Application for Removal or Variation of a Condition following Grant of Planning Permission or Listed Building Consent

Number	4
Suffix	
Property Name	Bridge Hotel
Address Line 1	Bridge Road
Address Line 2	Sutton Bridge
Address Line 3	Lincolnshire
Town/city	Spalding
Postcode	PE12 9UA

Change of use from hotel Class C1 to residential Class C3 including the creating of 15 residential units

H18-0463-24

|                                                                                       | 4 Bridge Rd,<br>Sutton Bridge,<br>Spalding<br>PE12 9UA | 723-18-B                                       |

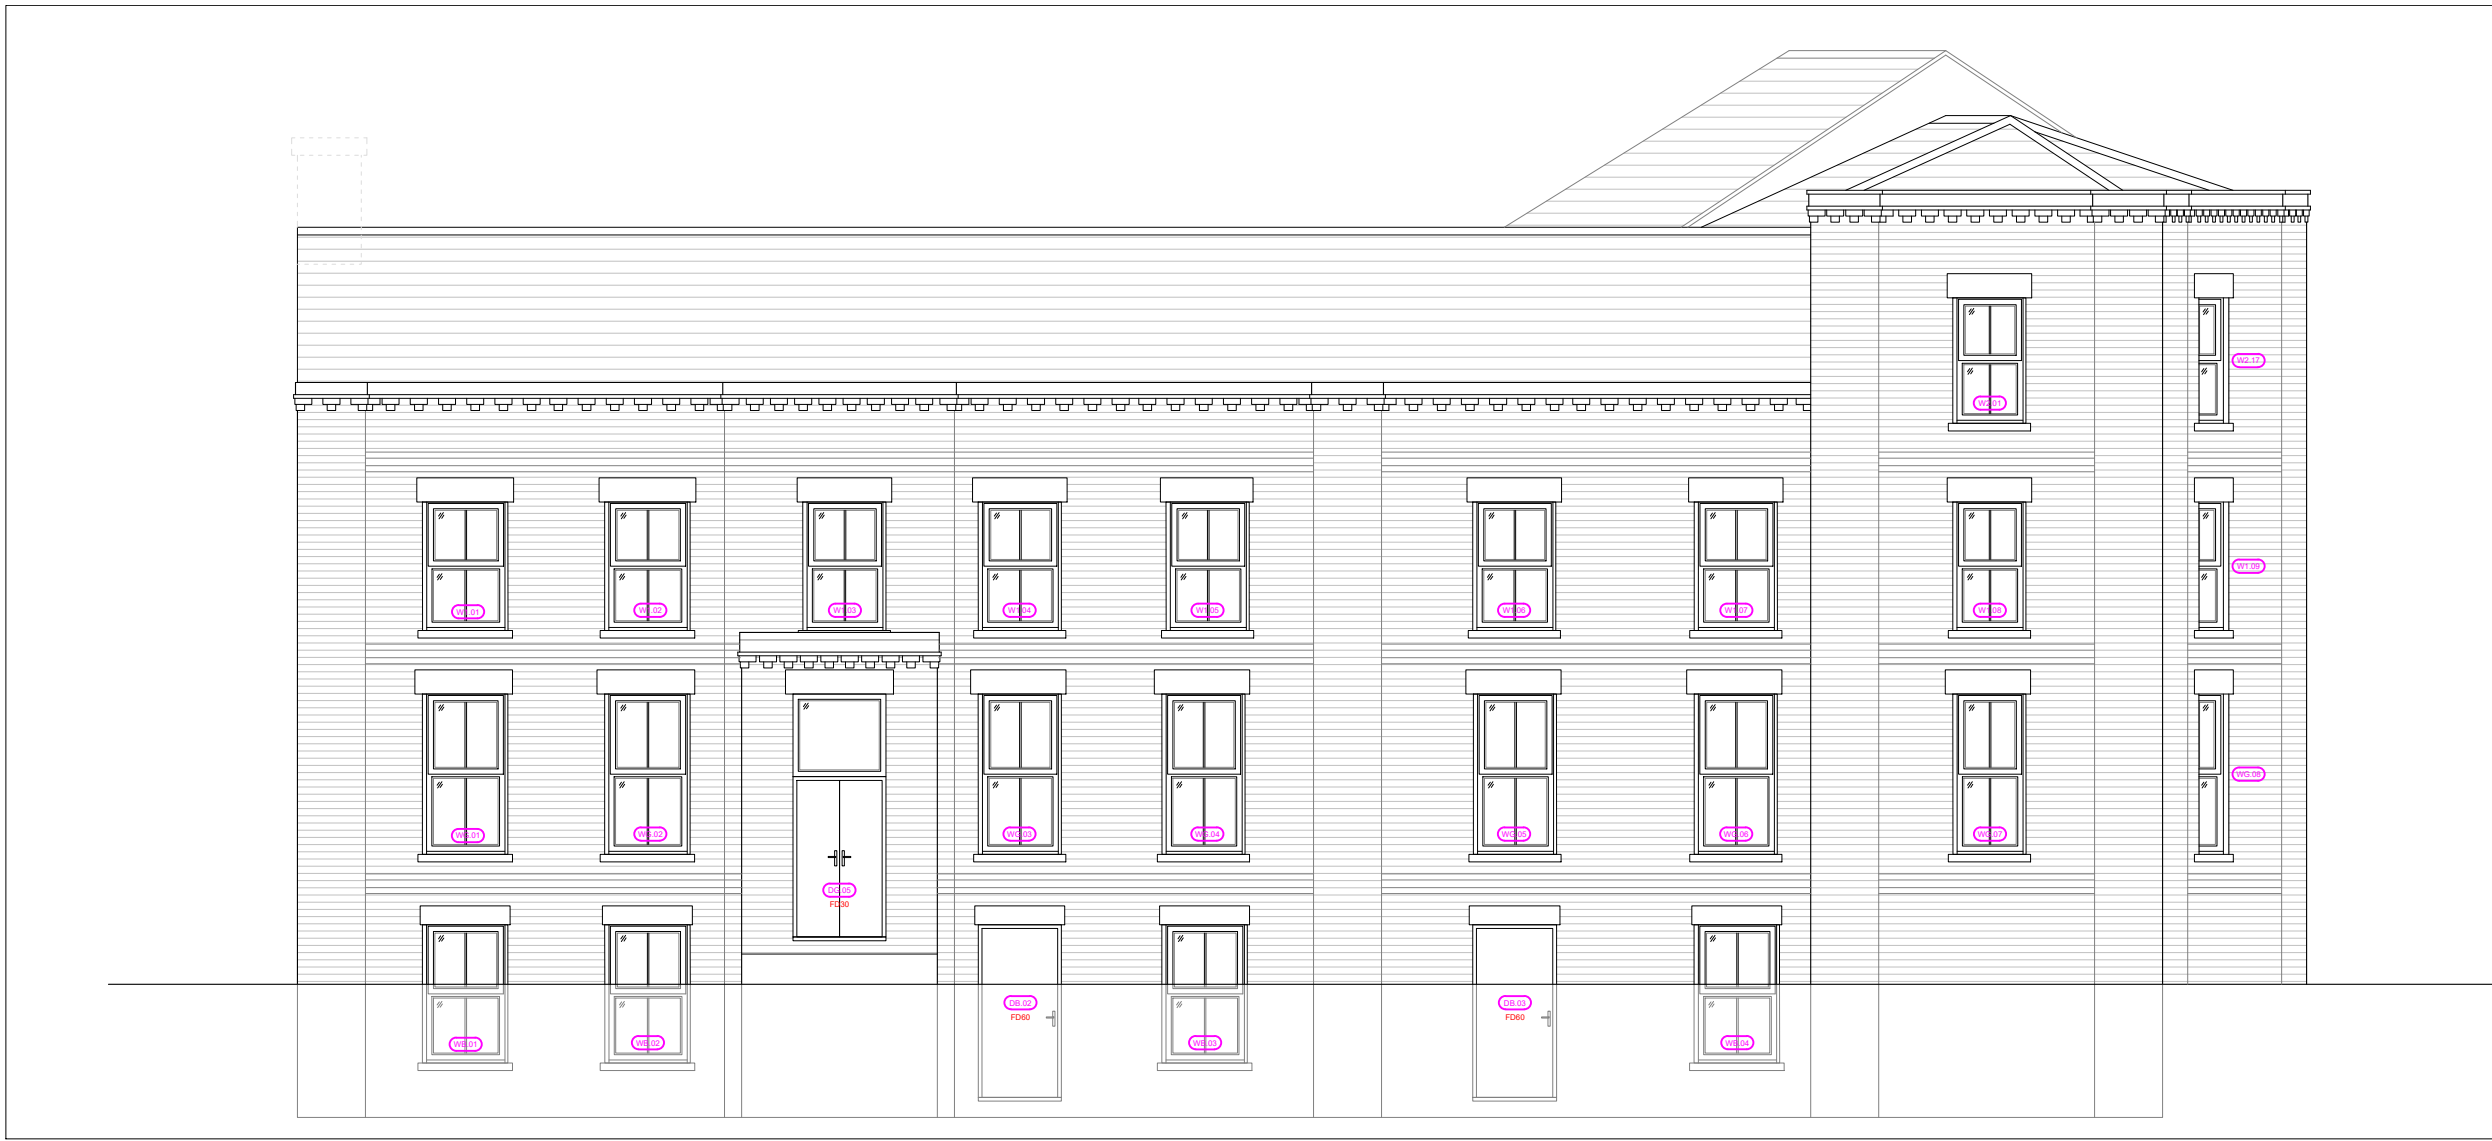
Amendments to the drawings set to ensure a greater level of accuracy after receiving more data from third party surveys. Unit 15 within the attic space has required minor changes to window placement and roof scape to ensure sufficient outlook and floor space for the occupants of that unit.

The drawings set on the application including: 723-04-E, 723-05 - To be replaced with the following drawings set: 723-18 Elevations VOC and 723-19 Second Floor Plan. The rest of the previously submitted drawings are to remain the same.
